Recommendation Report

AW/5/13

New barrel vault roof light, new marley cedar weatherboard cladding, soffits and fascias, re-arrange position of existing rooflights and repairs to existing chimney (additions to previously approved planning permission AW/140/10/)

33 Aldwick Avenue Aldwick

DATE	Aug 12	DRAWN	AS	CHECKED	-
JOB NUMBER	3106	DRAWING NUMBER	PR10	REVISION	A

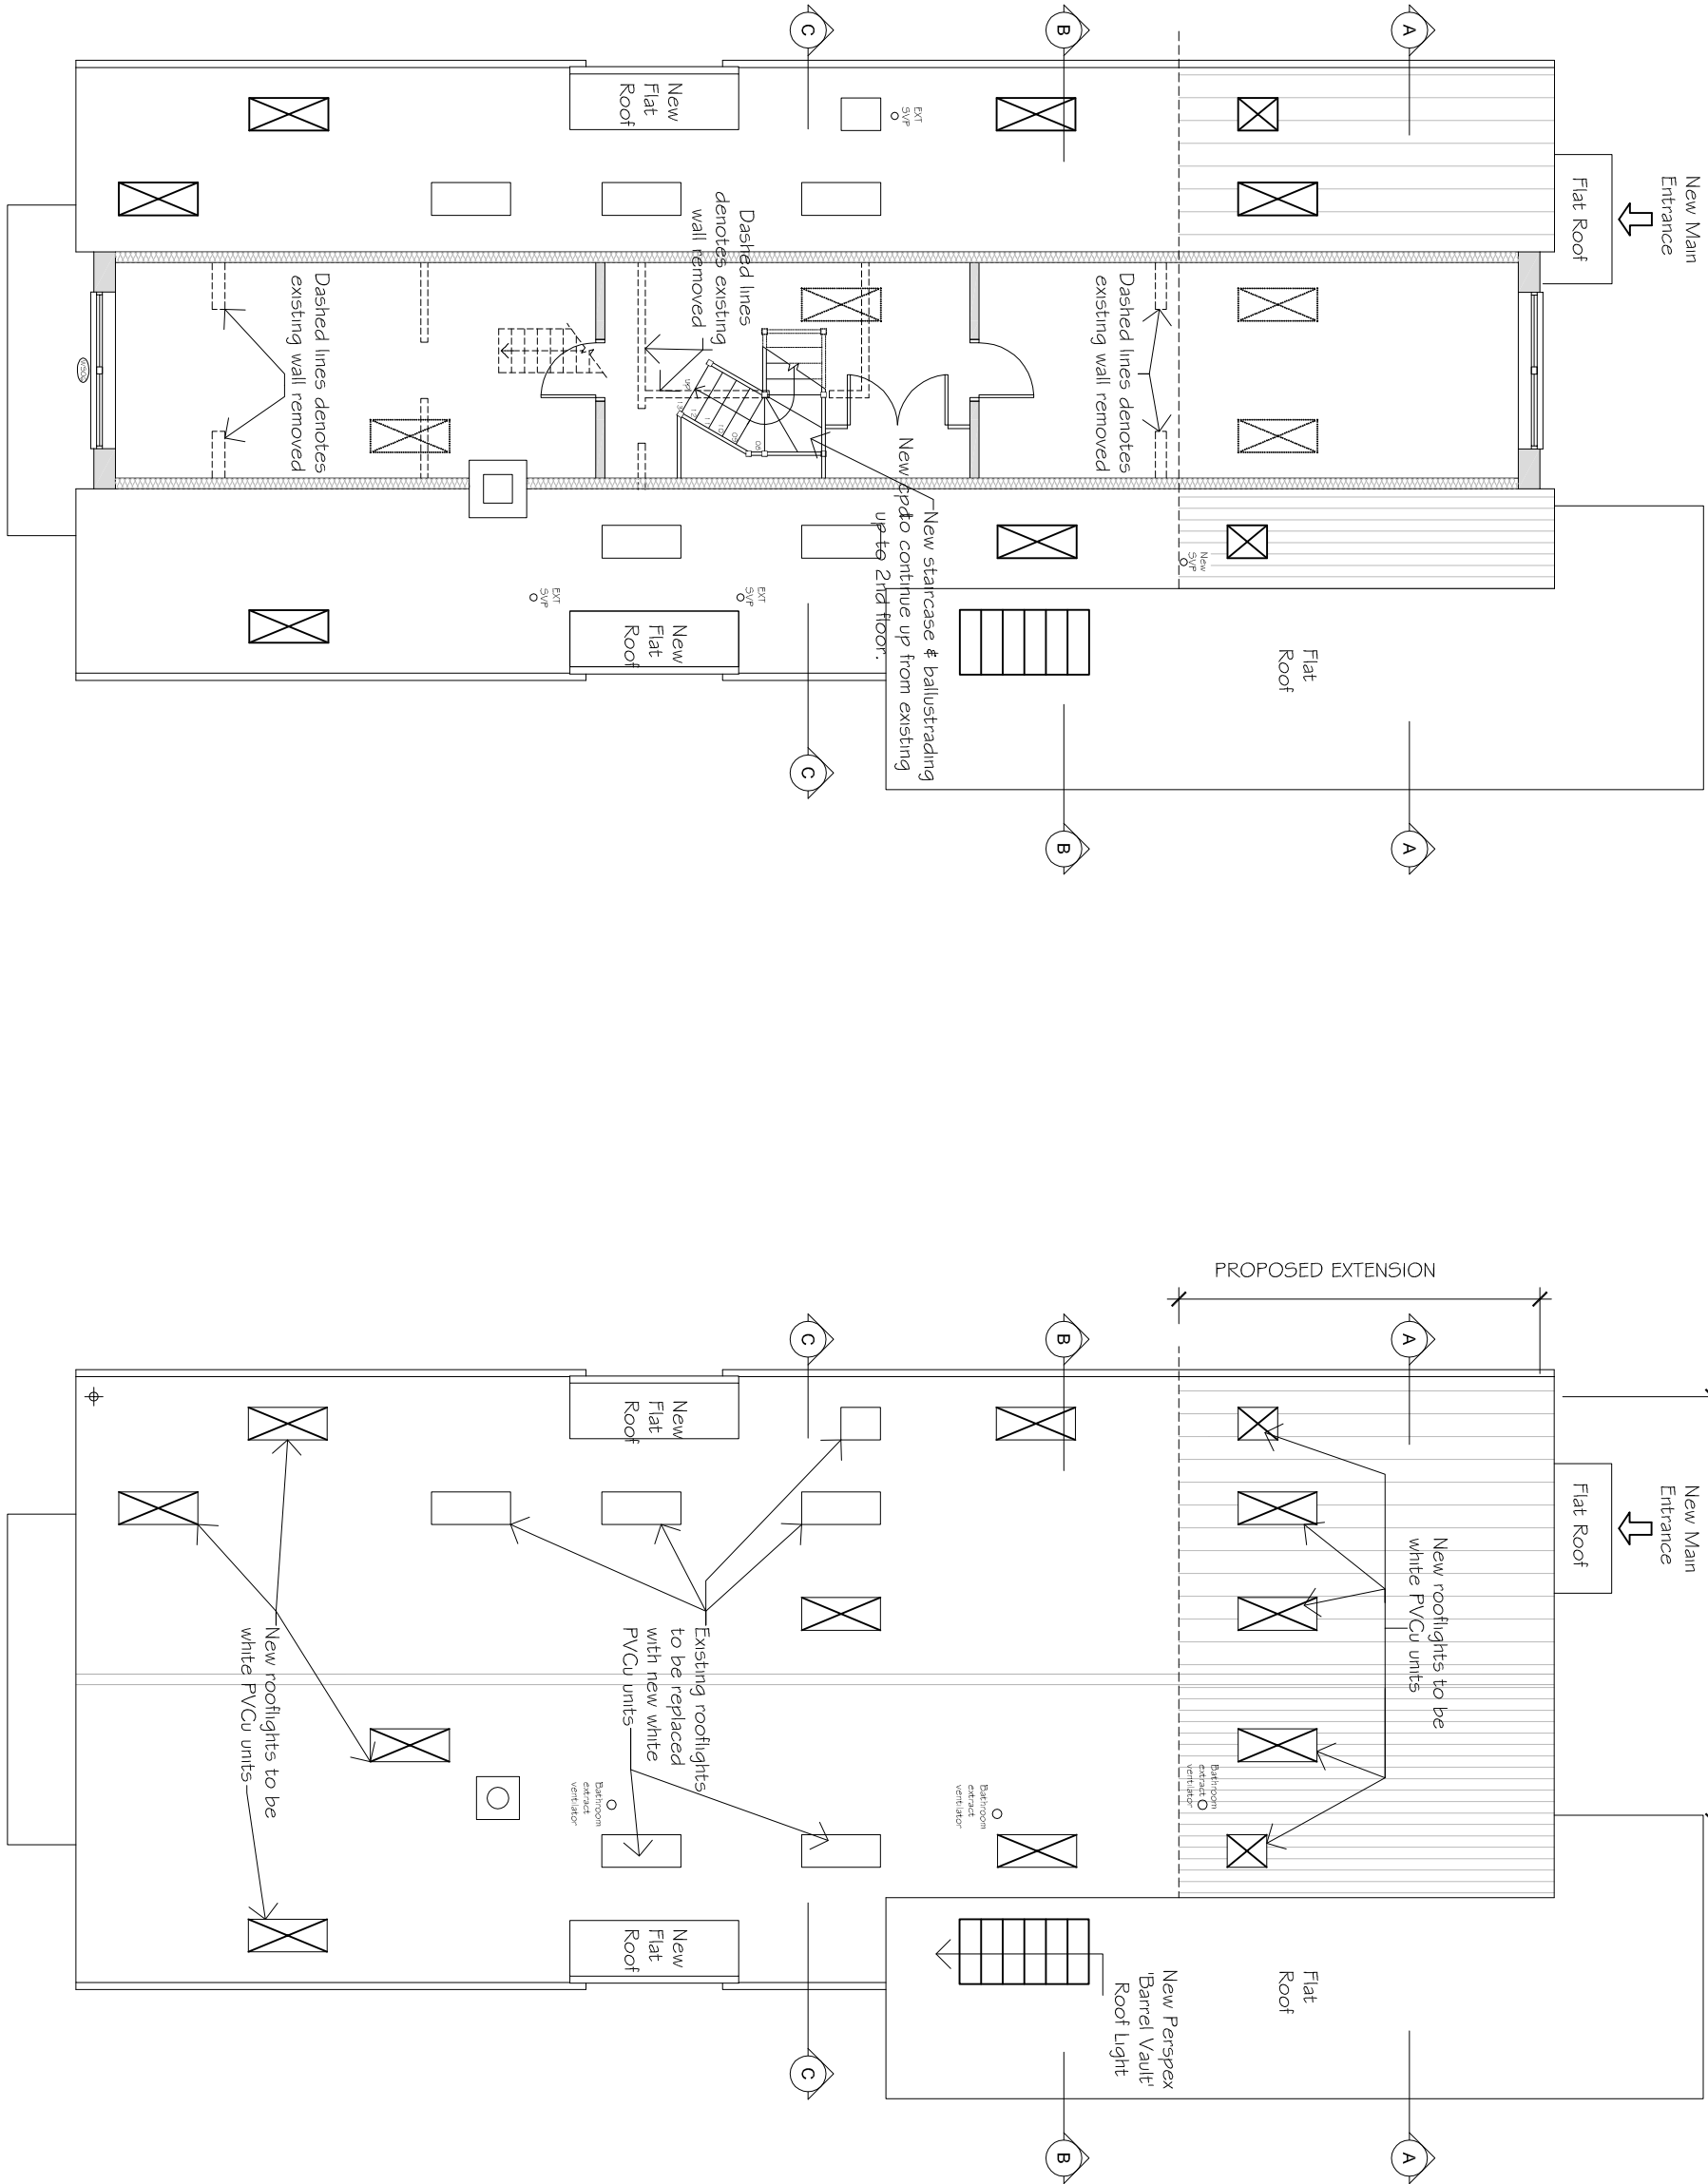
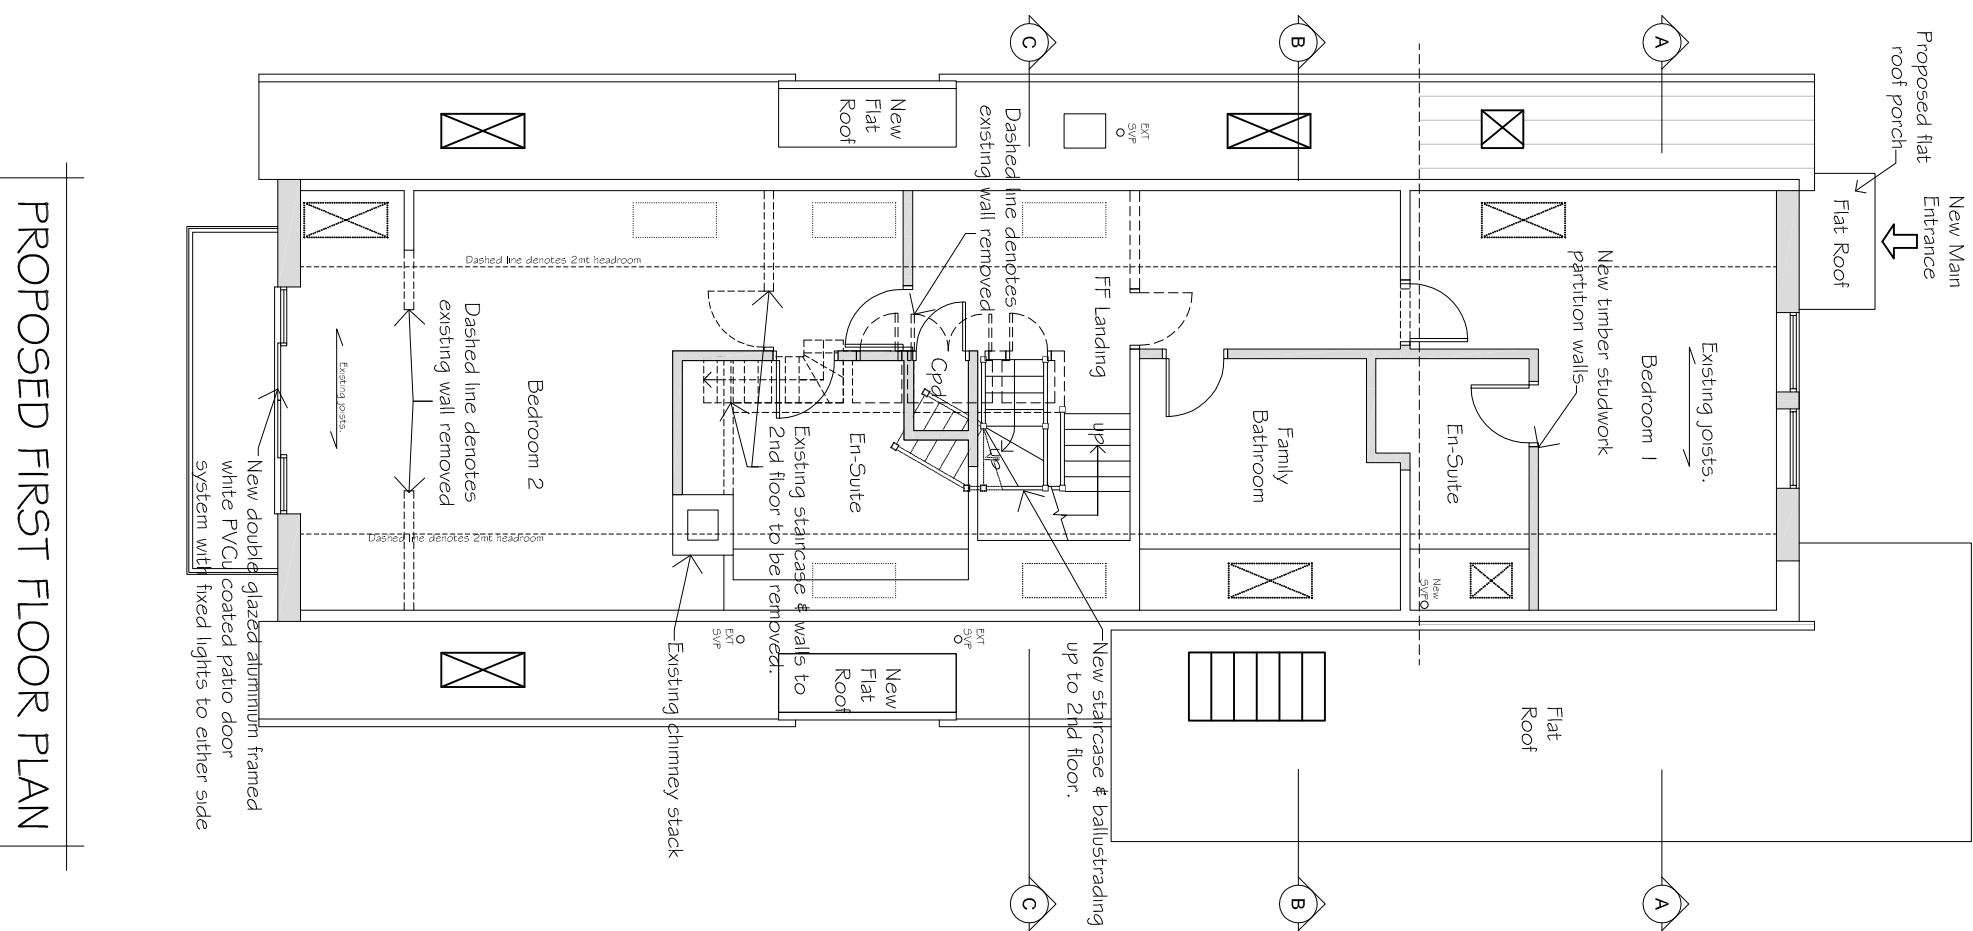
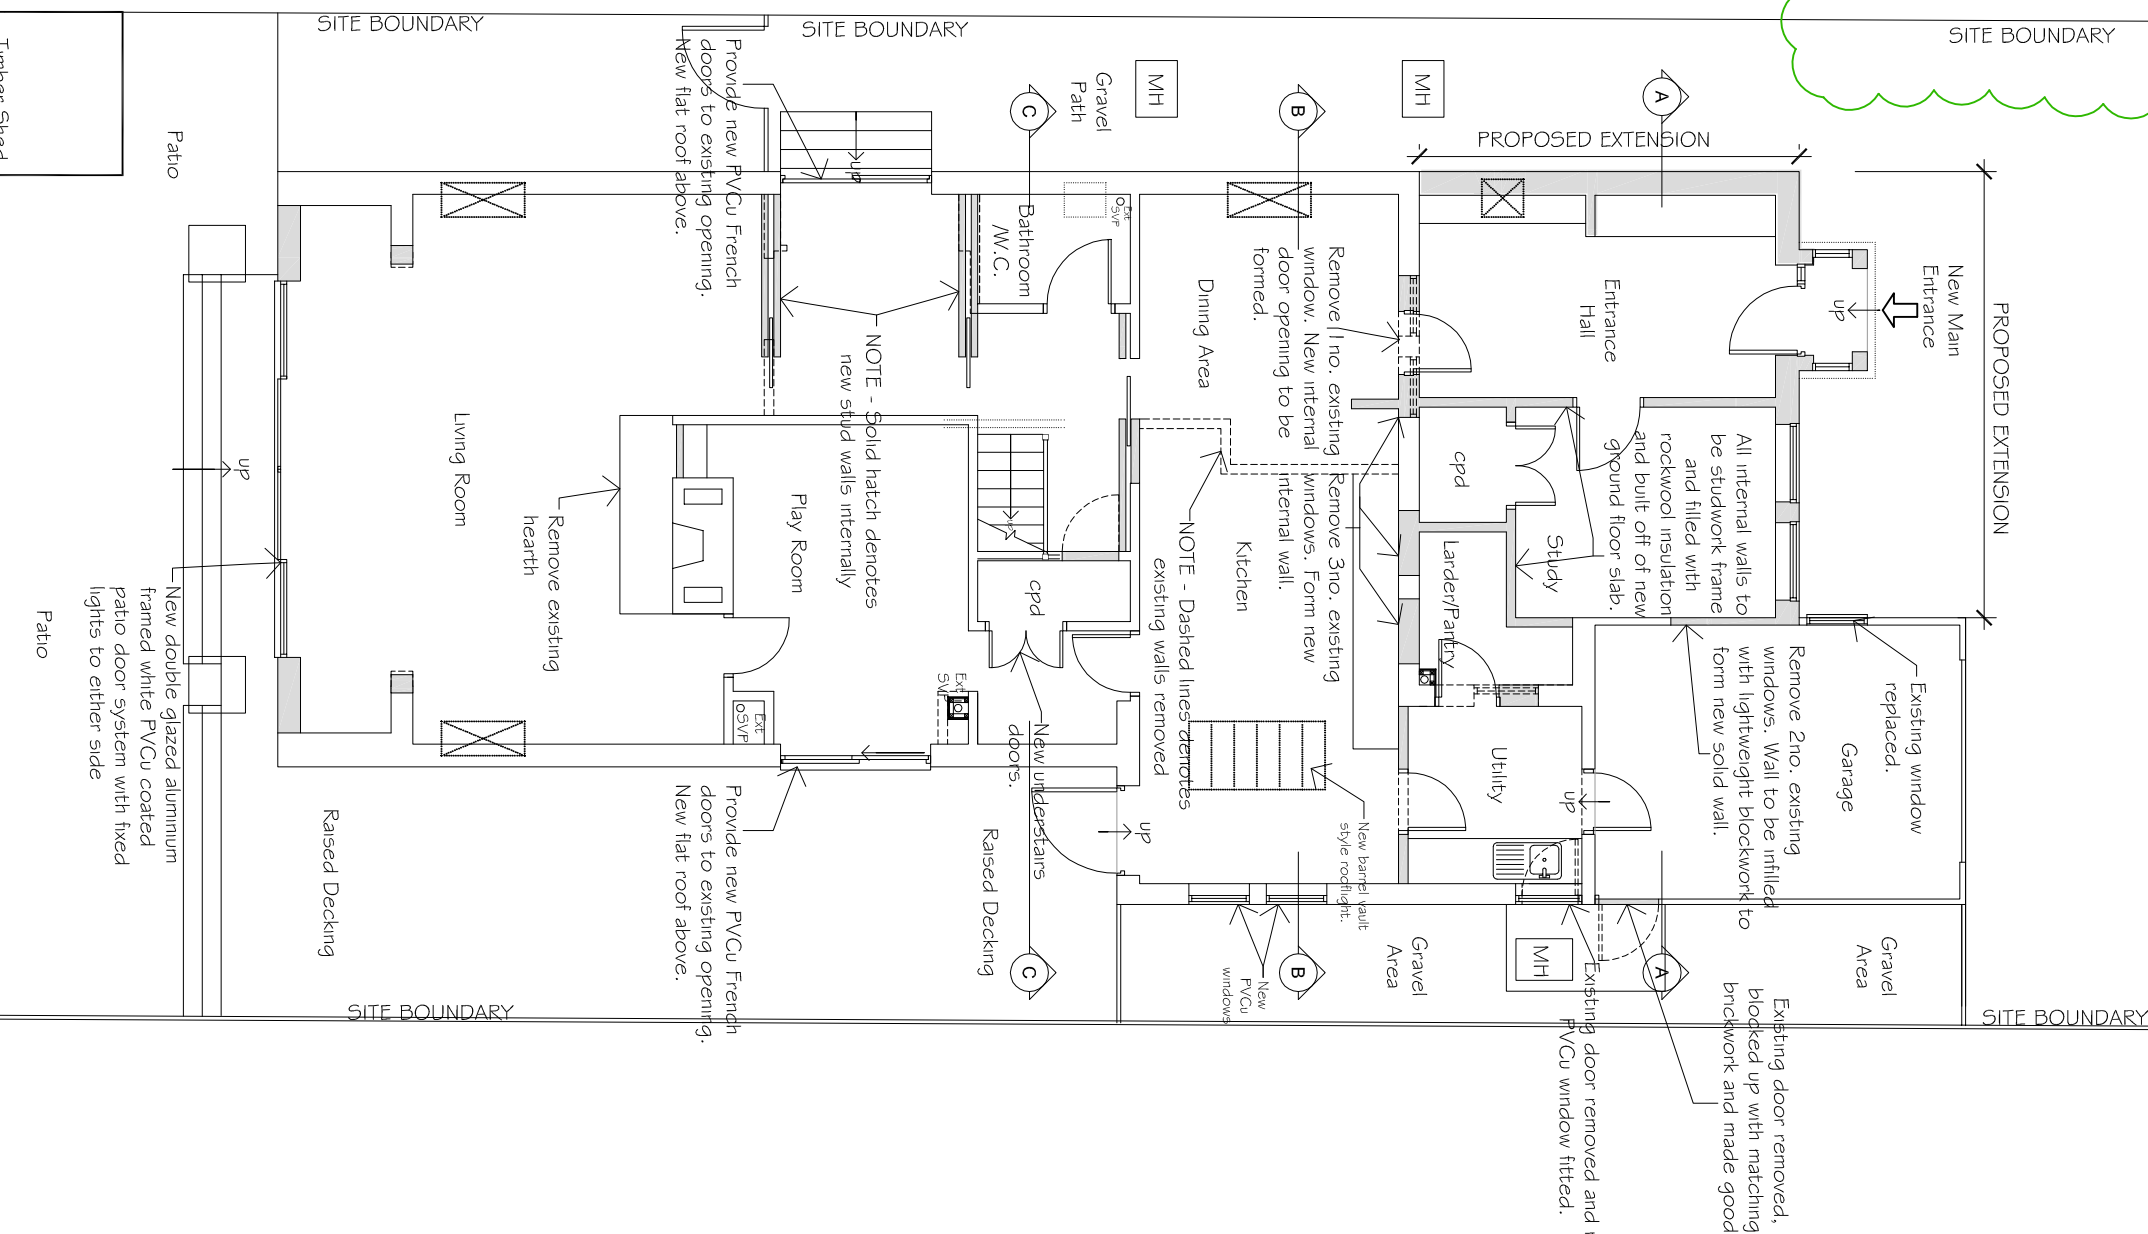
Unfortunately, the Block Plan, at a scale of 1:500, does not scale with the Location Plan, at a scale of 1:1250.

As I was explaining on the telephone, if you do not wish to hatch/highlight the proposed works on the block plan, you may put in an email why you will not be providing this information. If the case officer decides, at a later date, that they would like the works shown on the block plan, they will be in contact.

Please submit 1 electronic or 3 paper copies of a block/site plan in accordance with the guidance notes available on our website detailed below (click on National List). Please highlight/hatch the proposed works.

The last pdf you sent to me showed the block plan scaled at 1:500, meaning the block plan and location plan did not scale correctly. Now that you have changed the block plan to a scale of 1:200, the plans now scale correctly.

I have attached drwg PR10 revA showing the block/Location plan combined and now scaled at 1:200 to show the information you insist upon as is permitted using your previously suggested information re the 'Validation Checklist, Local List of Requirements' page 4, section 4 last paragraph.
